Our reference: ECM: 8990055
Contact: Gavin Cherry
Telephone: 4732 8125

19 February 2020

**SSD 7348 - MOD 3 - Further Amendments to Concept Plan and Stage 1
and SSD10397 – Stage 2 Development Works, Oakdale West Precinct**

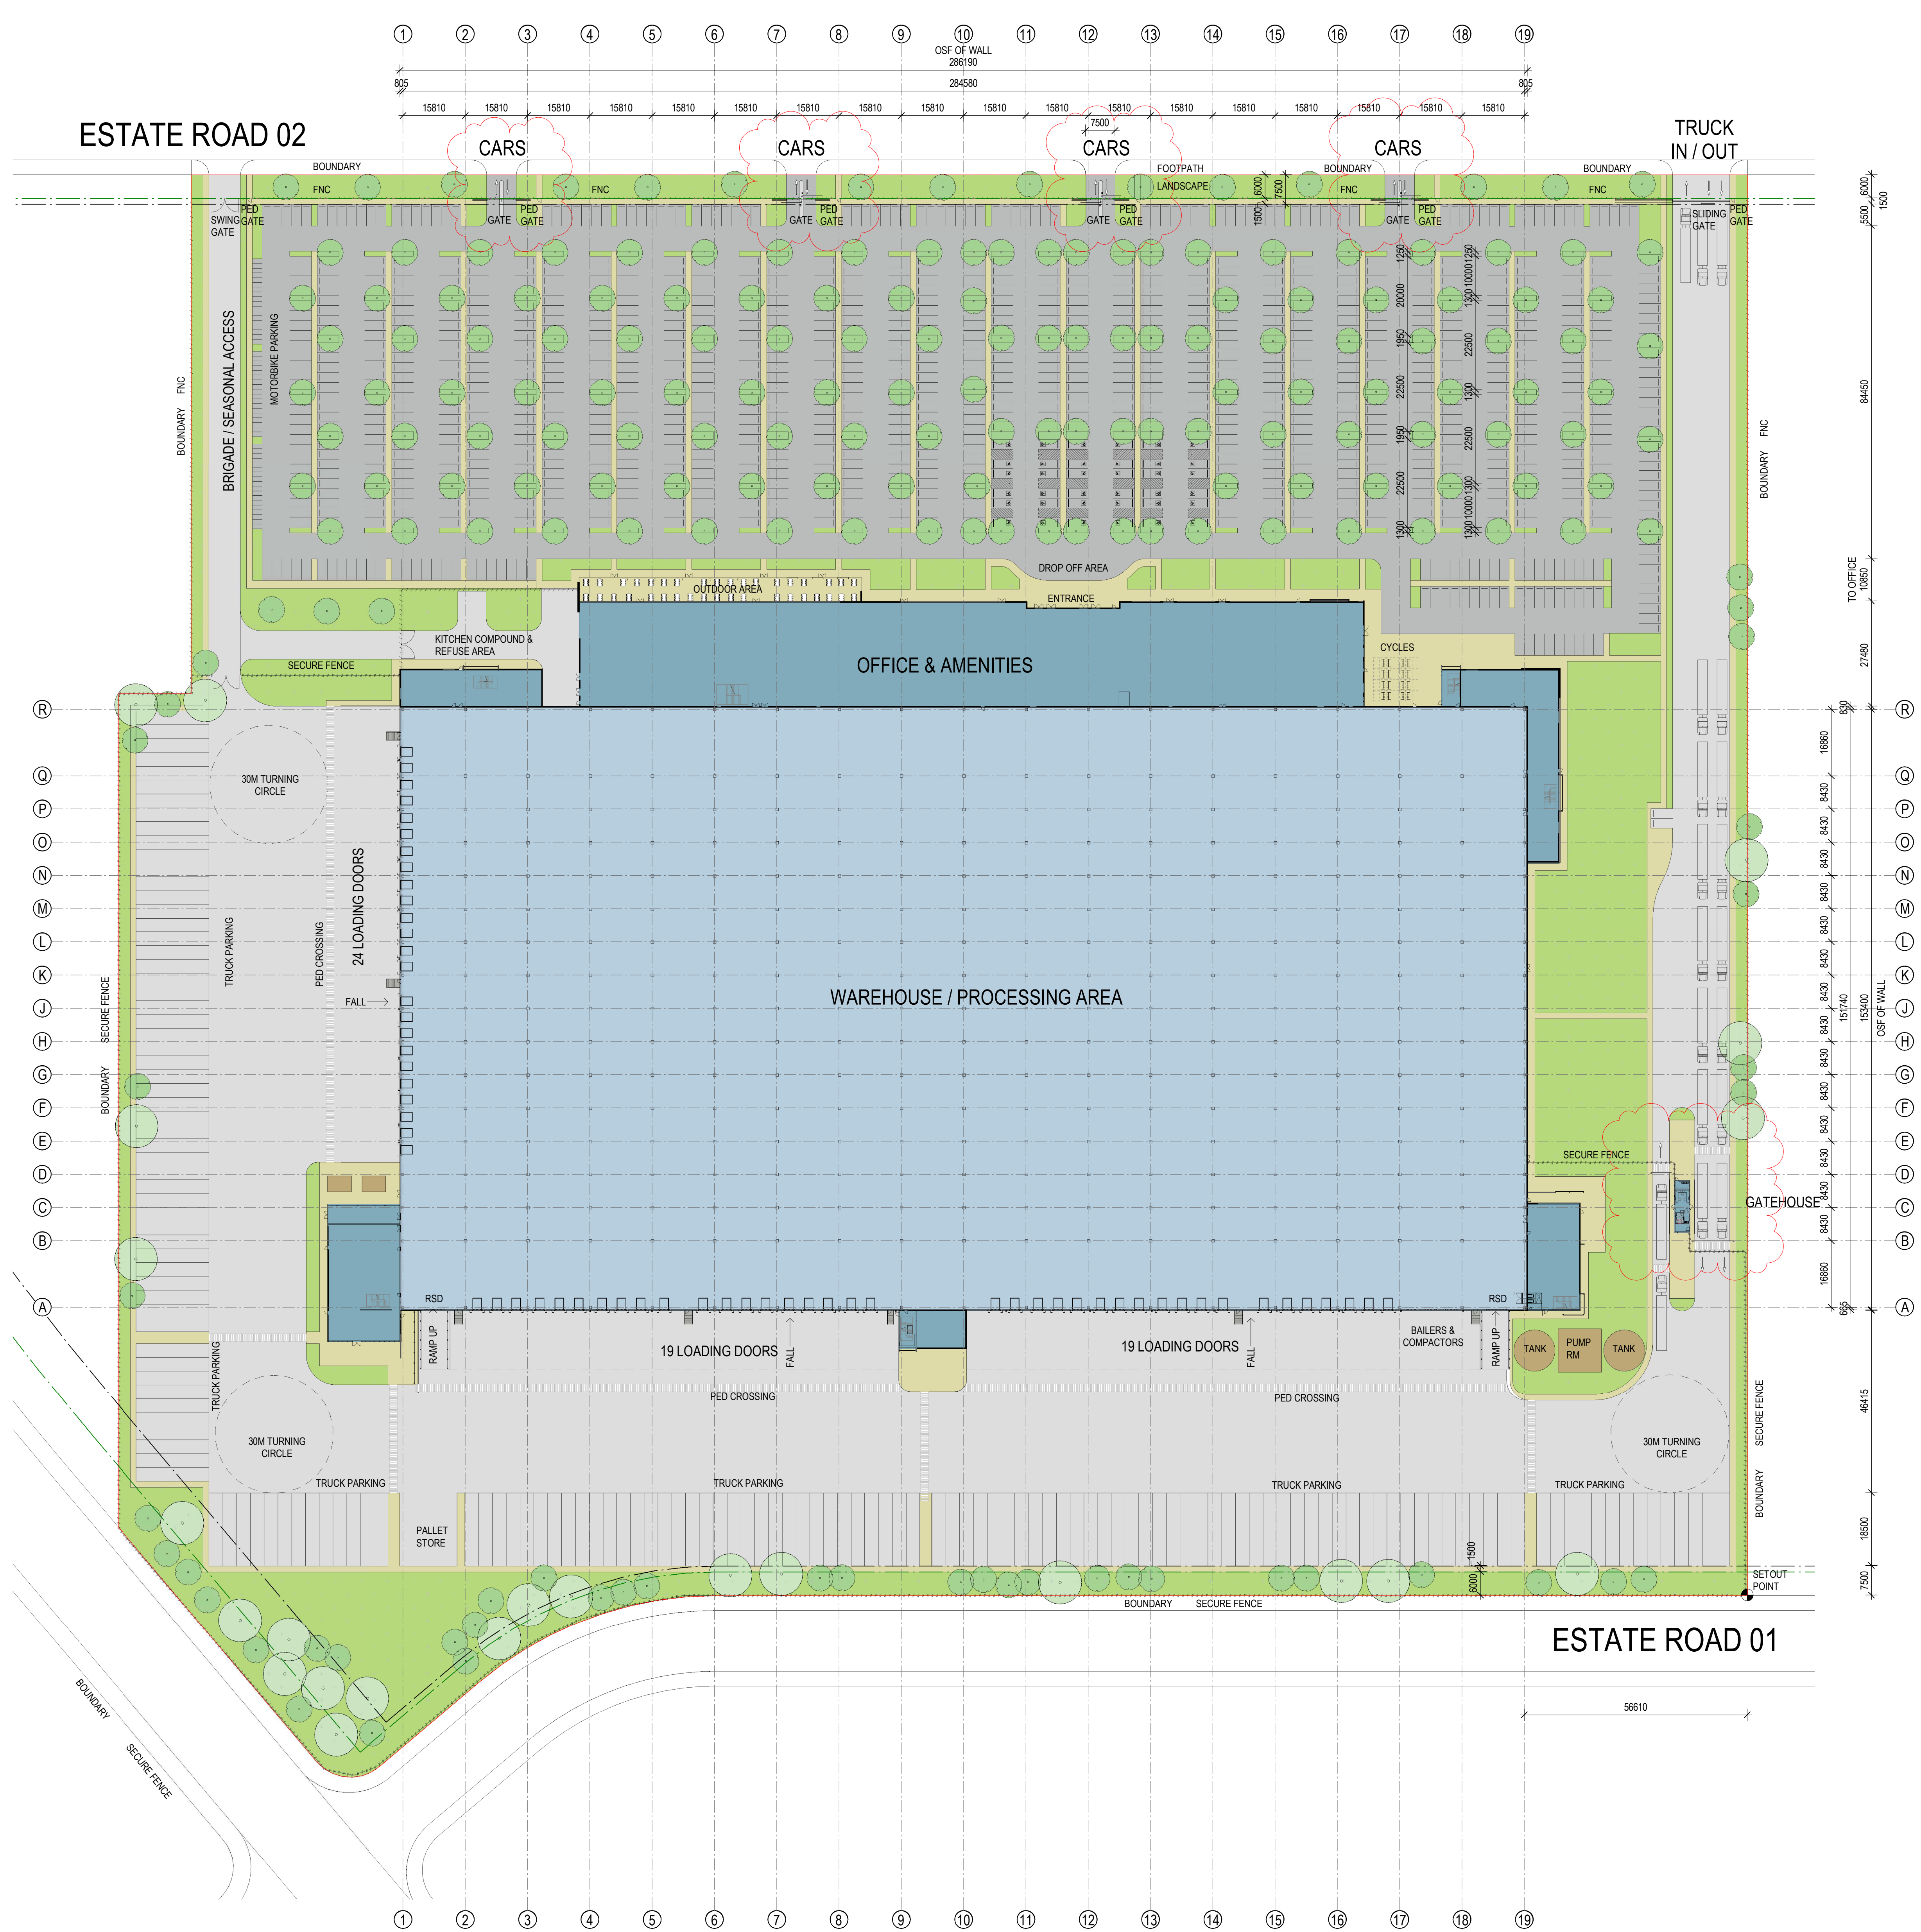
- The long bay car parking encroachment into the 20m setback zone adjacent to the southern link road is recommended to be amended to delete a small portion of parking that encroaches into the established setback line. This will improve the landscape design outcome along the link road. Given the nature of the link road, a consistent landscape setback along this arterial road is considered to be of particular importance.

- The provision of additional large canopy trees is requested within the corner setback to Estate Road 1 and the Link Road. The planting palette should include a variety of species and deference in mature heights. The planting currently indicated are virtually all small trees and will not achieve the canopy cover and spread required for this prominent corner. This could be addressed through conditions of consent requiring endorsement of the landscape plan by the consent authority or Council

- The plantings proposed within the setback to the truck / long bay parking adjacent to Estate Road 1 and Lot 2E must be sufficient to achieve screening of these hard stand areas. Concern is raised that the current planting arrangements will not provide sufficient screening and is it recommended that trees planted at 8-10m centres are requested within the front setback to Estate Road 1 and with understorey planting confirmed. The current plans do not provide specificity of understorey planting beyond a general schedule and palette mix. A planting matrix and density details are requested within all boundary setbacks to clearly identify the boundary edge conditions and the quantity and specific species of planting intended. At present, quantities are only indicated for trees throughout the landscape design. This could be addressed through conditions of consent requiring endorsement of the landscape plan by the consent authority or Council

Figure 7: Sensitive Noise Receivers and Noise Wall Locations

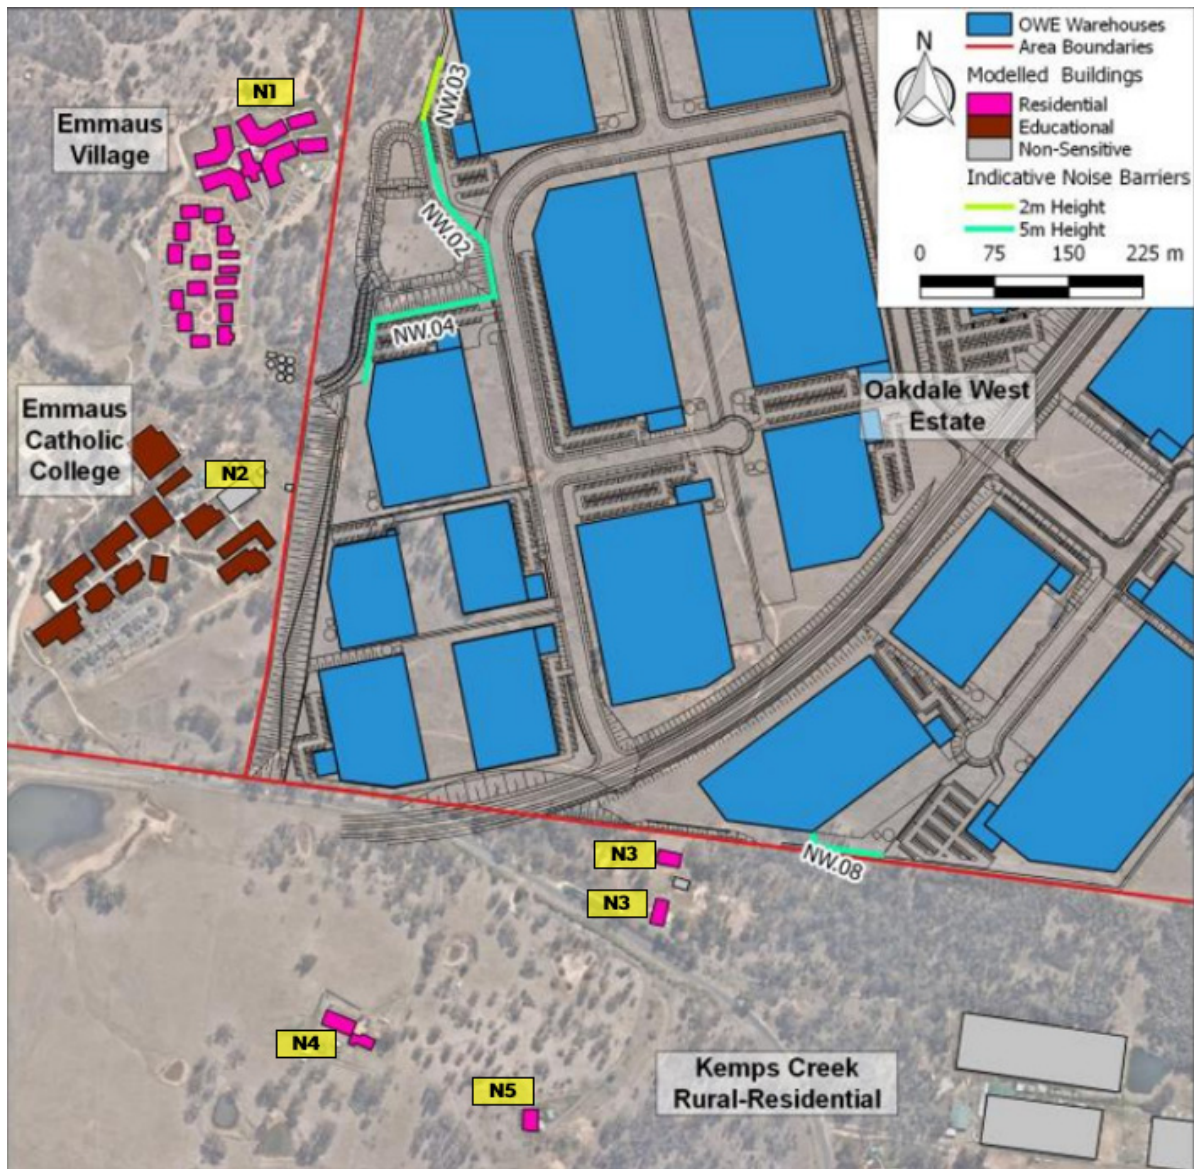
- As raised within the planning comments in the Mod 1 response by Council, the reasonableness of a 5.0m acoustic wall on top of an elevated fill platform with extensive retaining wall is not supported. It also appears from the information submitted that further noise mitigation measures may still be required at receiver boundaries. It appears that negotiations are currently occurring with neighbouring properties and that 'at-receiver' noise mitigation measures are not yet finalised. The impacts of the completed development and the implications of necessary mitigation measures can only be assessed if the full extent of mitigation measures within the site and at receiver boundaries are included within the assessment and plans. If the suggestion is made that the ultimate impacts are unknown due to current analysis being based on predications only, then the predications should be conservative in nature and include likely mitigation measures at receiver boundaries to understand what could be required after construction and occupation.

- approved noise limits will be achieved for typical and peak operations under all meteorological conditions at receivers to the west of the OWE, and
- exceedances of noise criteria at night under noise enhancing weather conditions at residential receivers (N4 and N5) to the south and south west of the site. The NIA identifies that due to the elevation of the receivers to the south, noise barriers at the source will be of little effect to these receivers.
- The NIA states that the exceedances at southern receivers, N4 and N5, will occur only under 'relatively rare noise enhancing meteorological conditions' coinciding with the six week end of year peak season. The NIA does not predict the frequency of noise enhancing weather conditions, such as temperature inversions.

- It is noted that development of the OWE in stages will mean that Lot 2B and Precinct 1 will operate for a substantial period prior to the full development of the OWE and it is during this stage that the most noise impact will occur to receivers N4 and N5 to the south.
